**Preliminary Acceptance Punchlist**  
**El Paso County – Department of Public Works - Stormwater Section**

Project Name:	Security Fire Station #4
EDARP Filing Number(s):	PPR2029 CON2228
ESQCP Number:	ESQ2223
Attendees:	DPW SW: Glenn Reese, Dylan Finley DPW Dev Services: David Parkerson Developer: Neil Parker
Date of Walk-Thru:	05/23/2023
Walk-Thru Number:	1

SECTION A-A

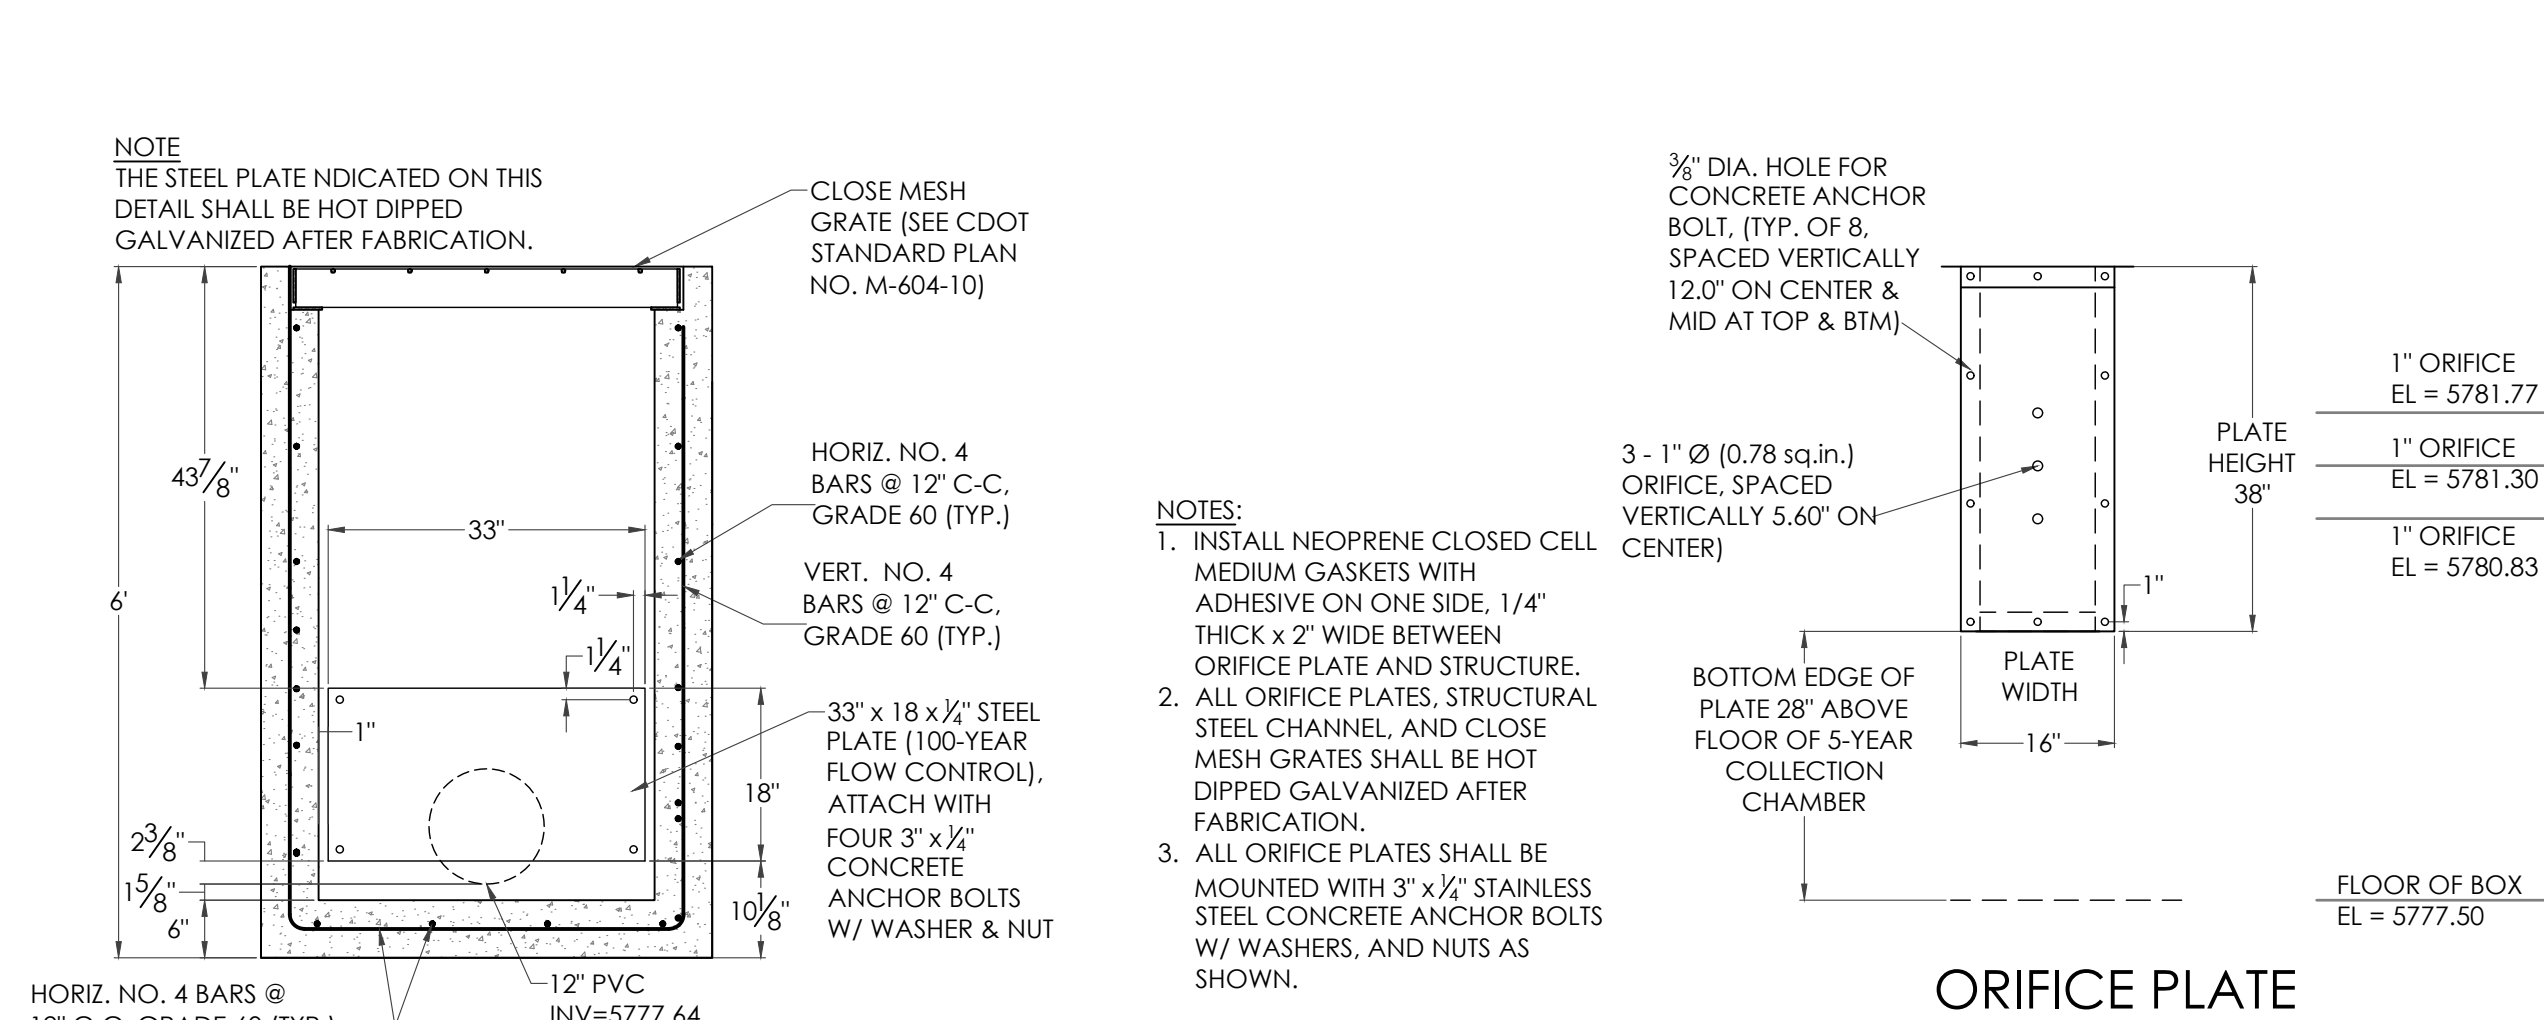
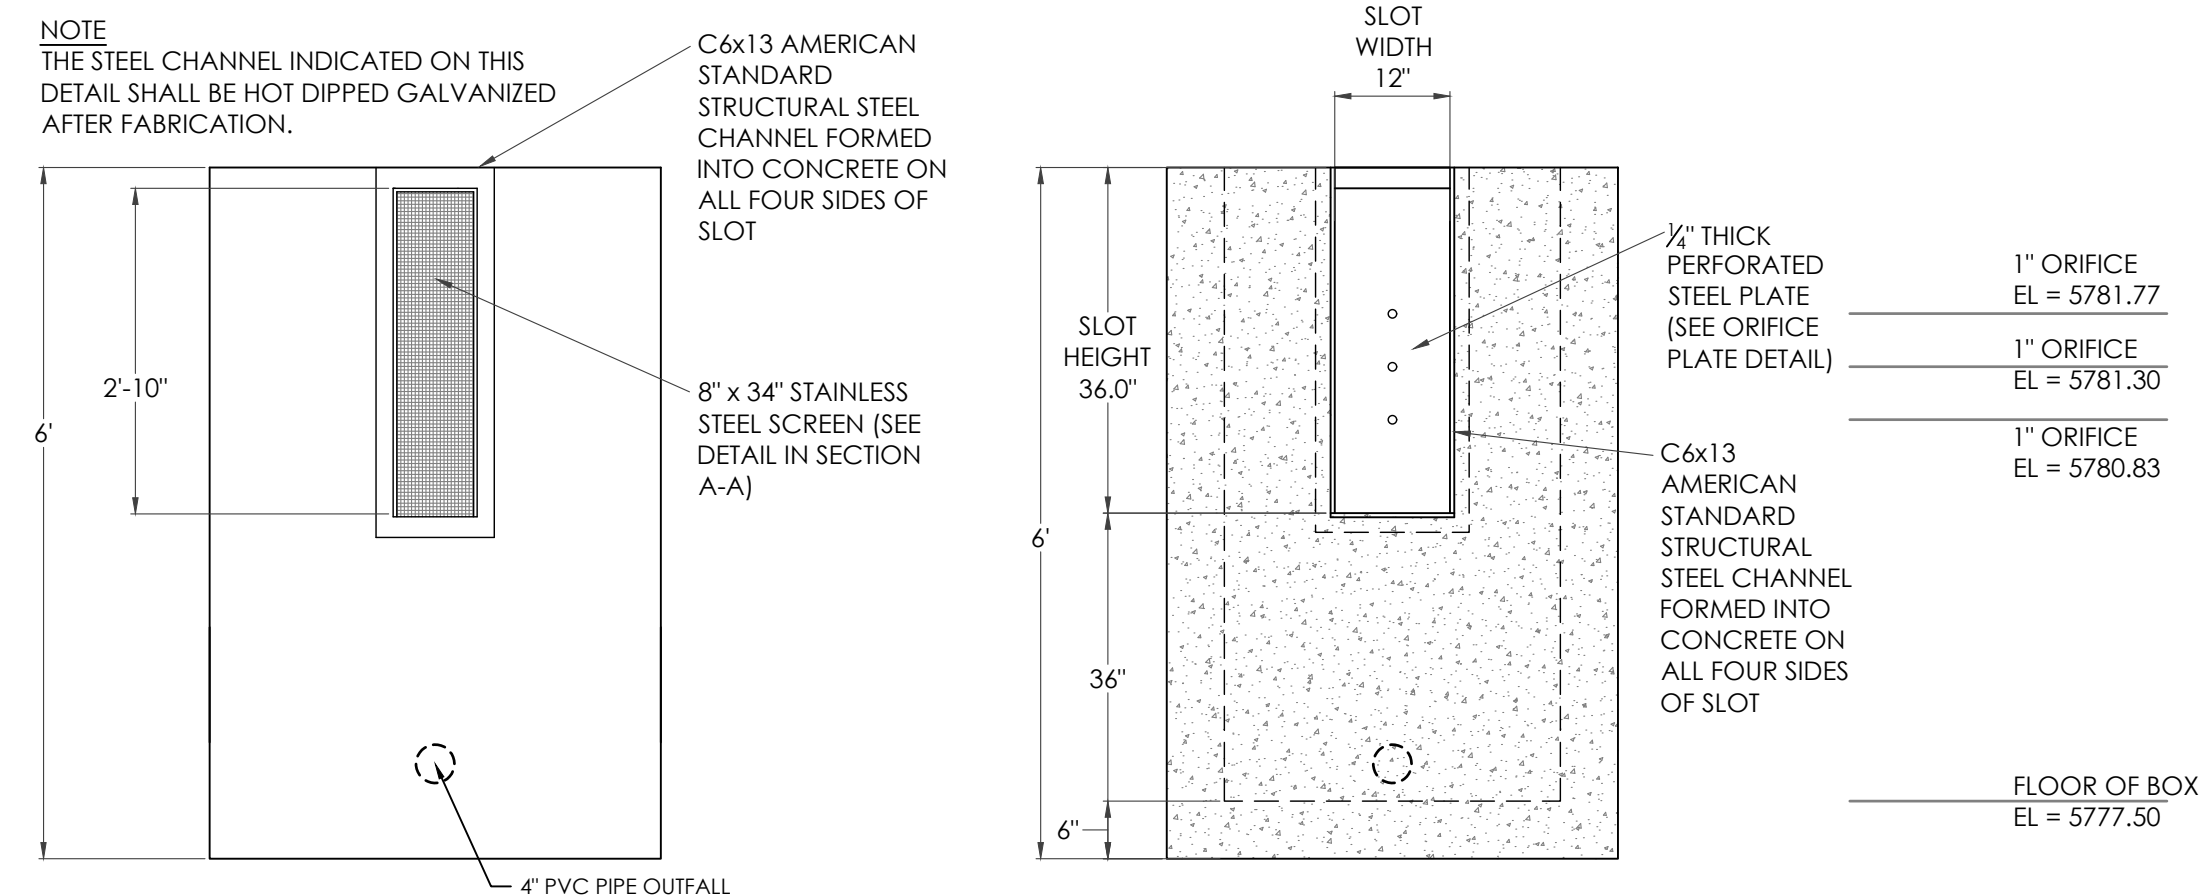
- Section A-A shows the dimension from the invert of the underdrain to the bottom of the orifice plate at 30". However, the field measurement was closer to 34". Make sure that this difference is reflected on the as-built plans and on the updated UD-Detention spreadsheet, because that may have affected the elevation of the orifice holes.

- Similar comment for the invert of the outlet pipe: Section A-A shows the invert of the outlet pipe to be elevated 1-5/8" above the bottom of the outlet structure. But it was instead installed flush with the bottom. Reflect on as-built drawings and calcs.

- Engineering Record Drawings (as-builts) consistent with Section 5.10.6 of the ECM.
- Volume Certification Letter(s) for pond(s), see ECM Chap 5.10.6.B for details on what type of statement should be included in the letter.
- Re-submit UD-Detention spreadsheet per changes shown in as-builts. Can be included with Cert Letter.
  - If significant changes, would need to also submit an updated SDI Form.

GRADING & EROSION CONTROL PLAN POND PLAN

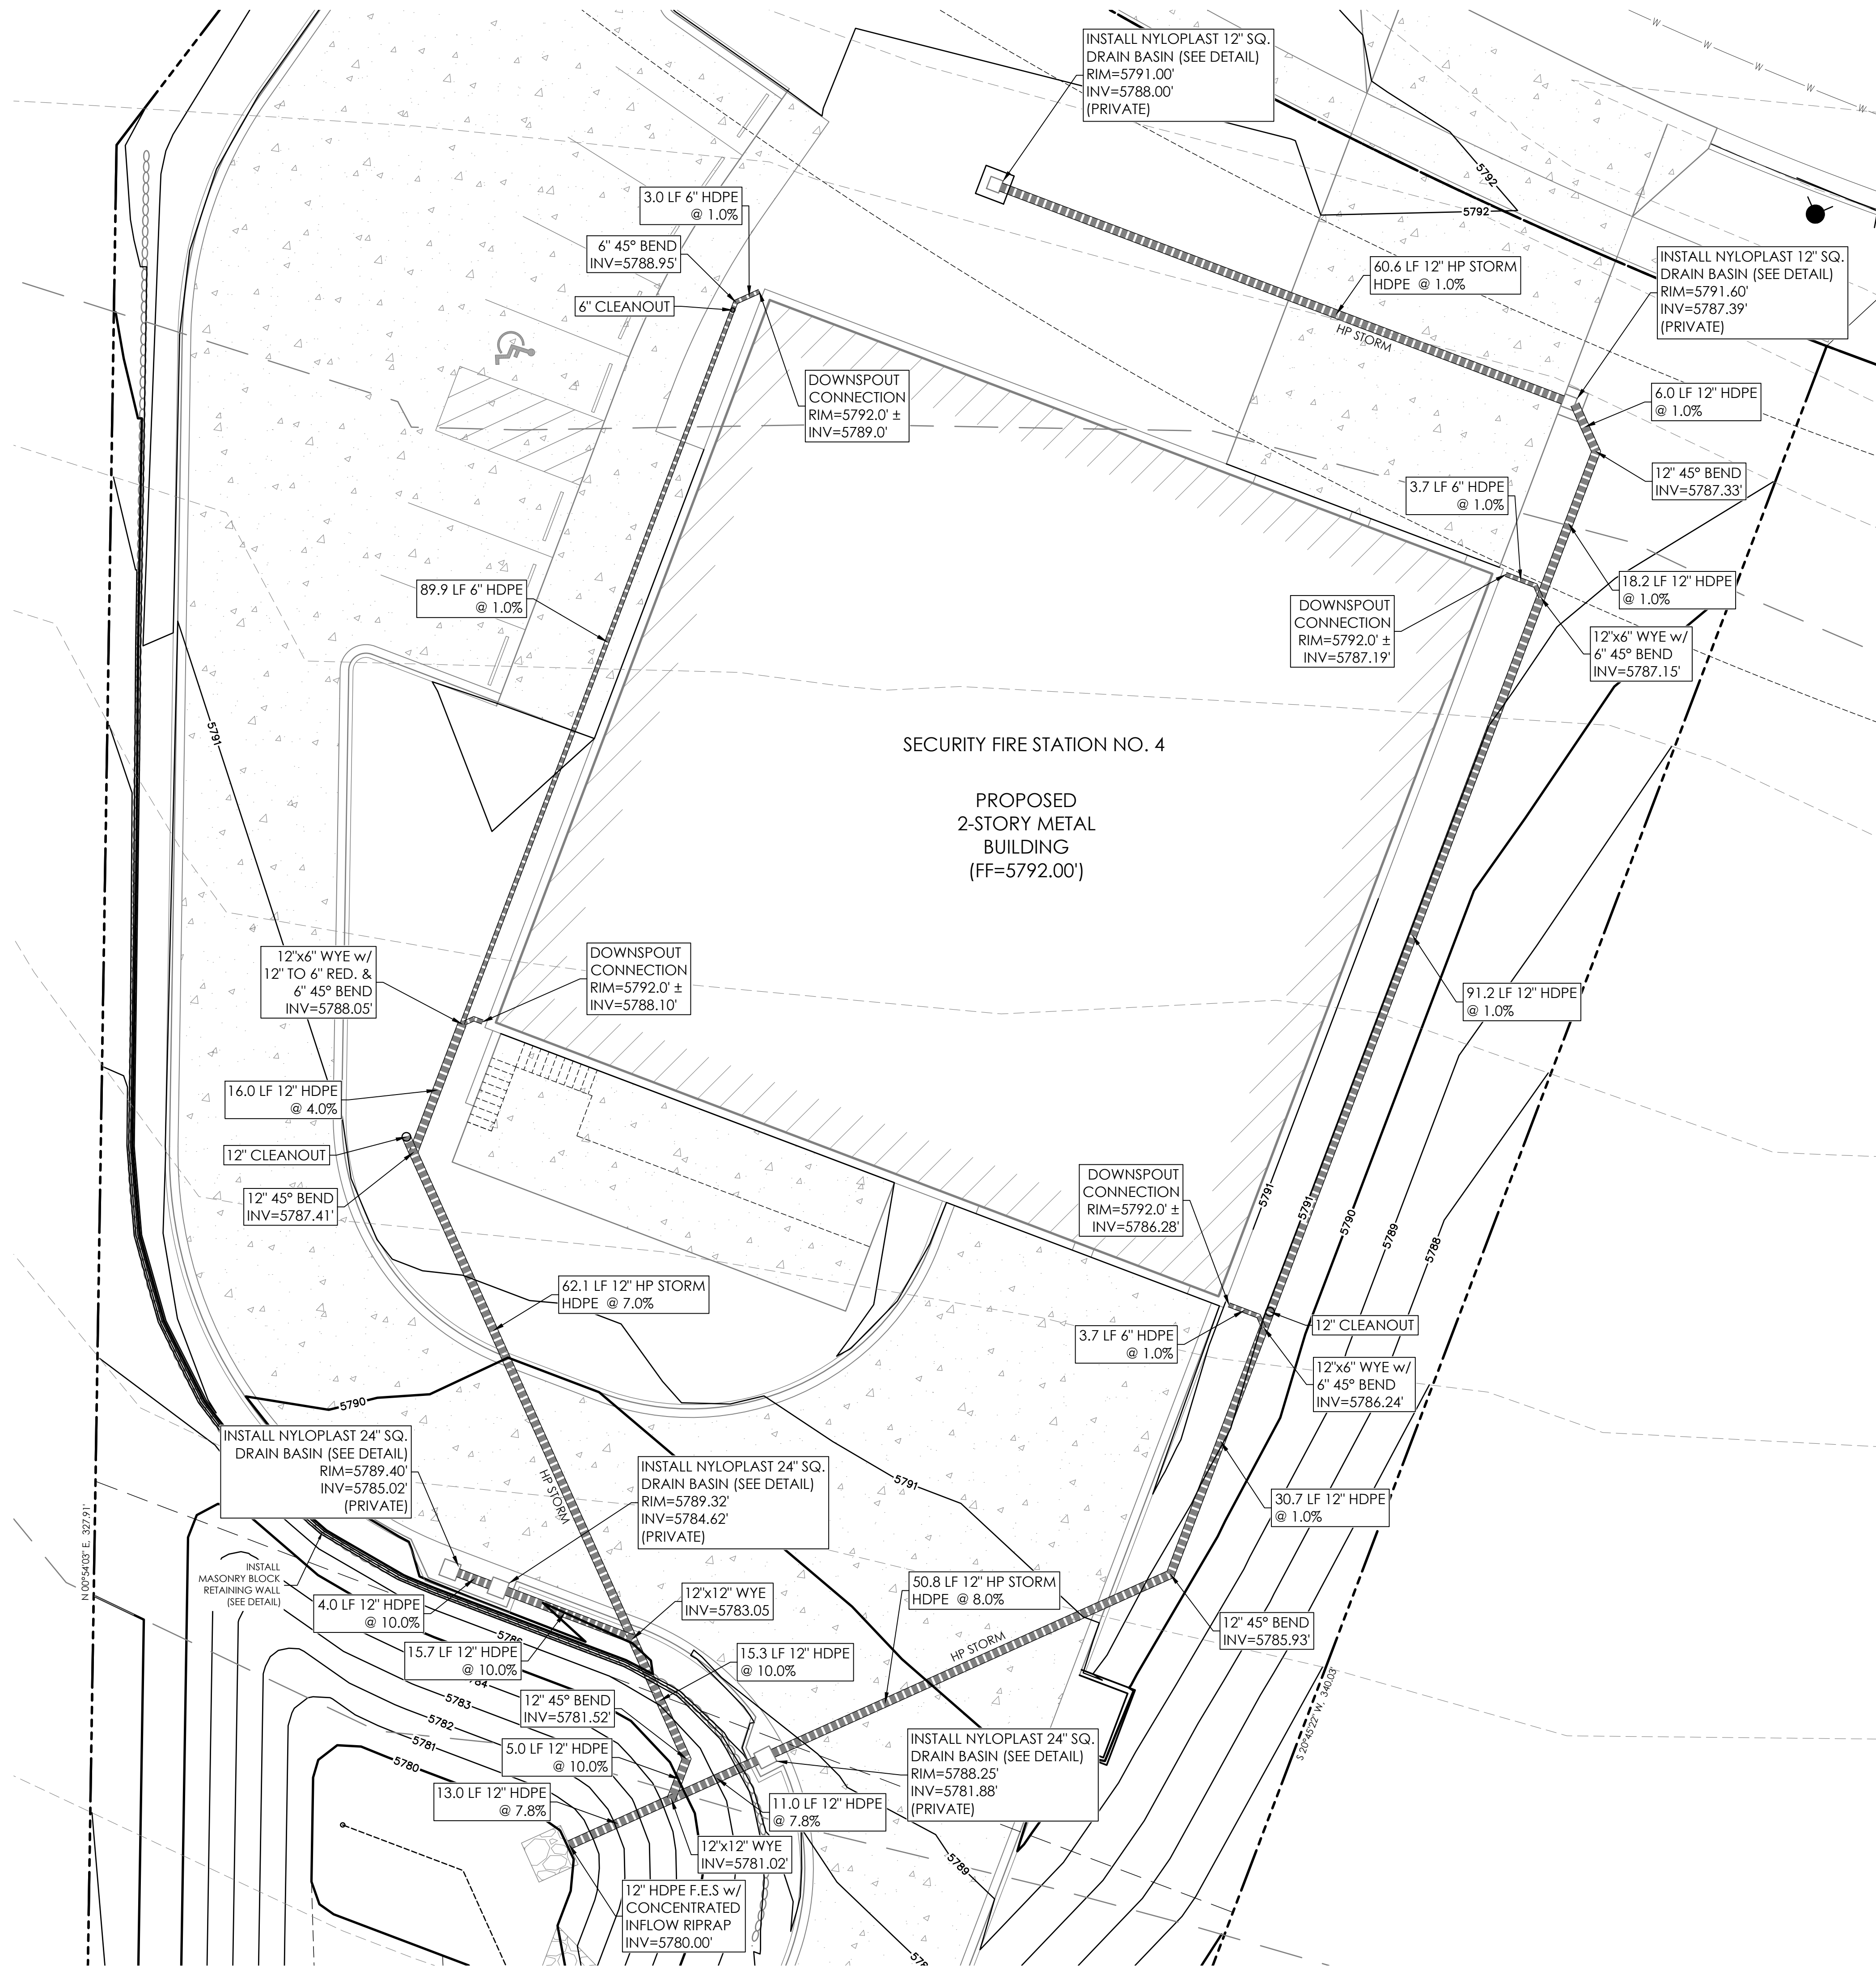
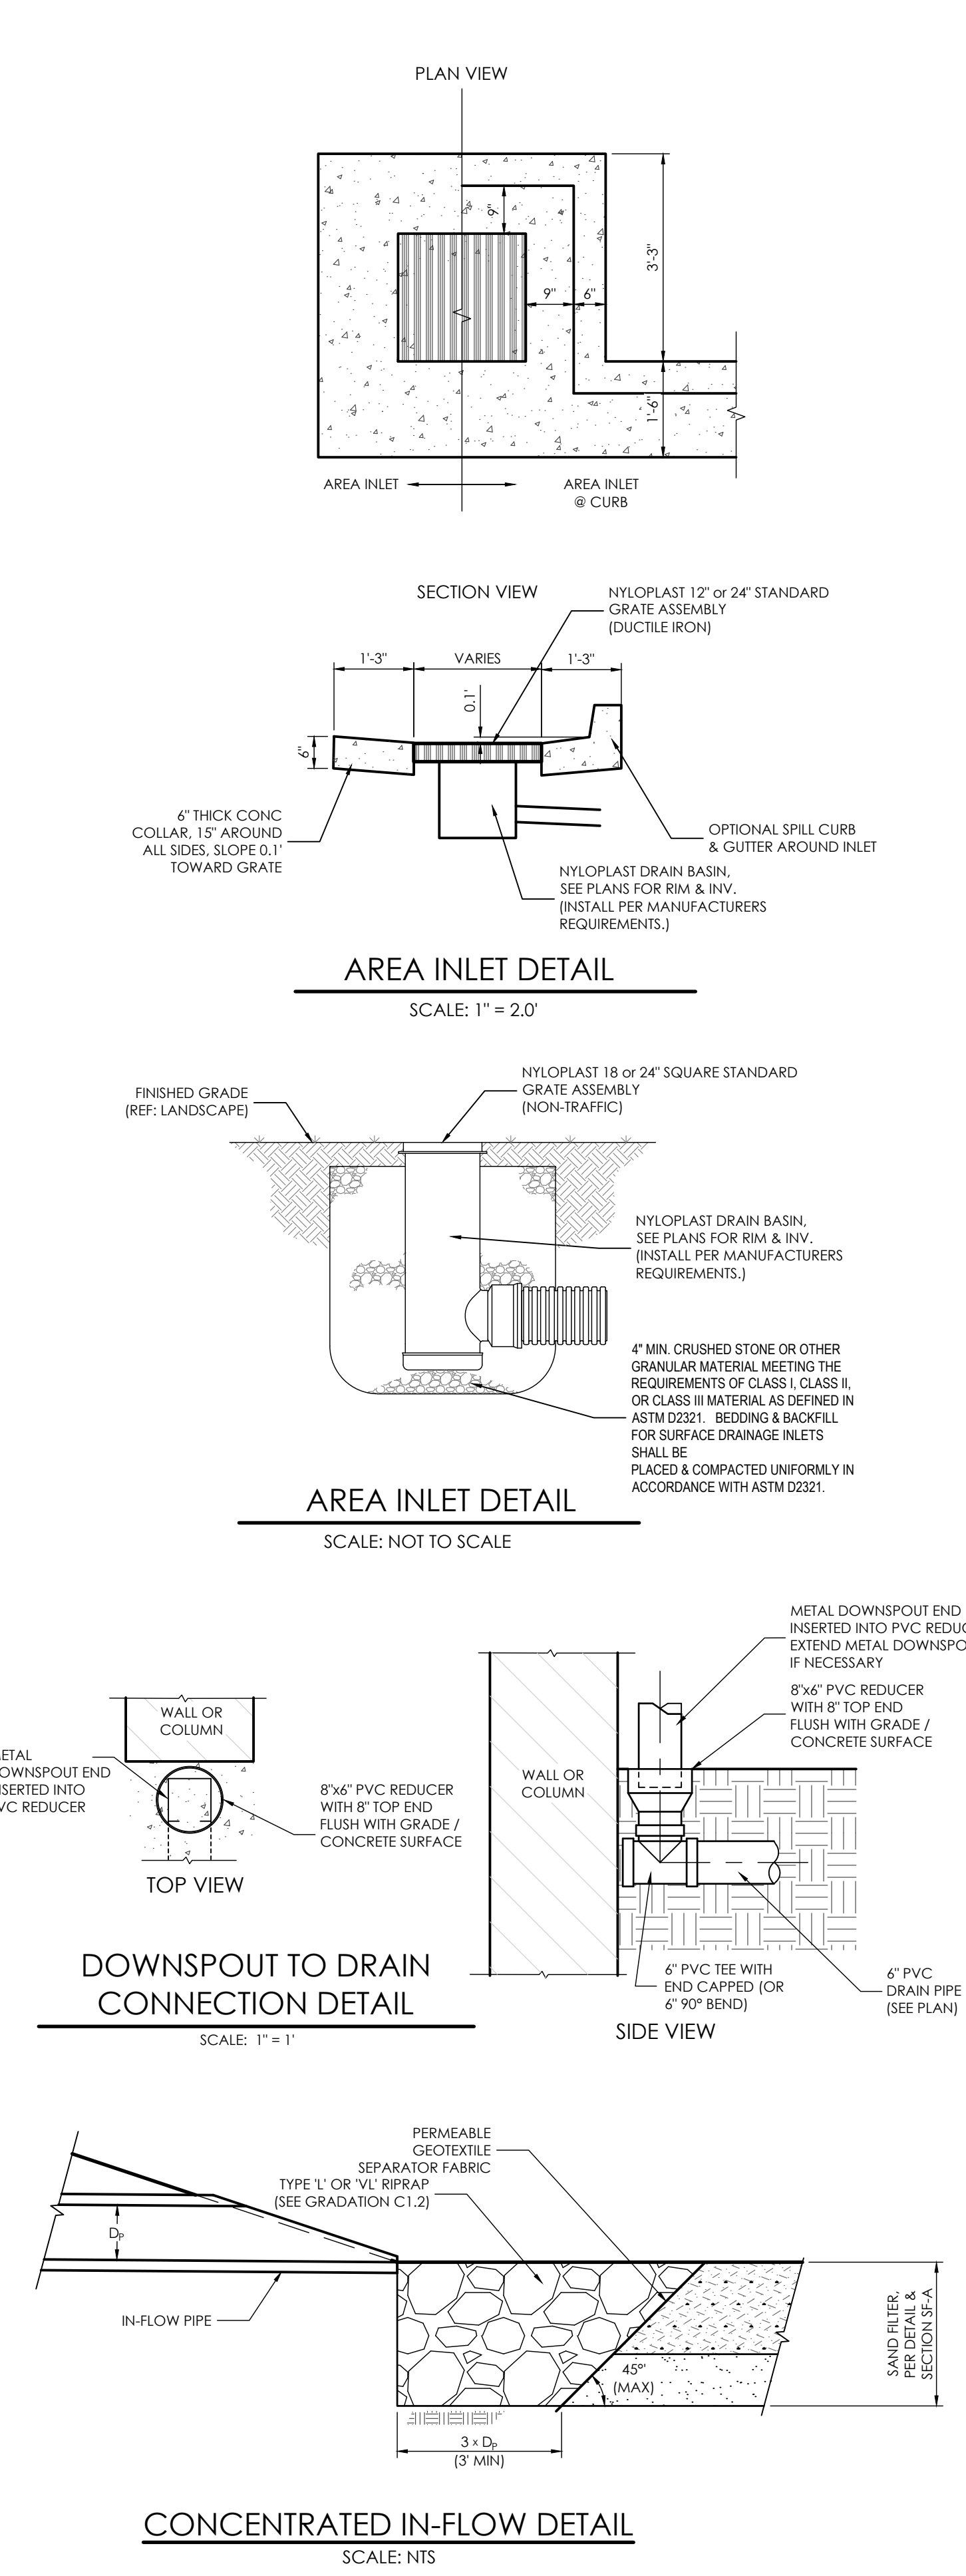
- Riser pipe for underdrain needs to be cut to an appropriate height.
- Gasket/caulking missing from orifice plate.
- Restrictor plate missing two bolts.

- Cleanout pipe was installed with slotted PVC pipe. Replace cleanout with solid pipe, otherwise stormwater can bypass the filtration media and go straight into the underdrain.

- Space between microscreen and orifice plate is not enclosed as shown on plans. This is a maintenance concern. In the field we discussed potentially bolting on a metal plate to cover the gap. Discuss options with project engineer.
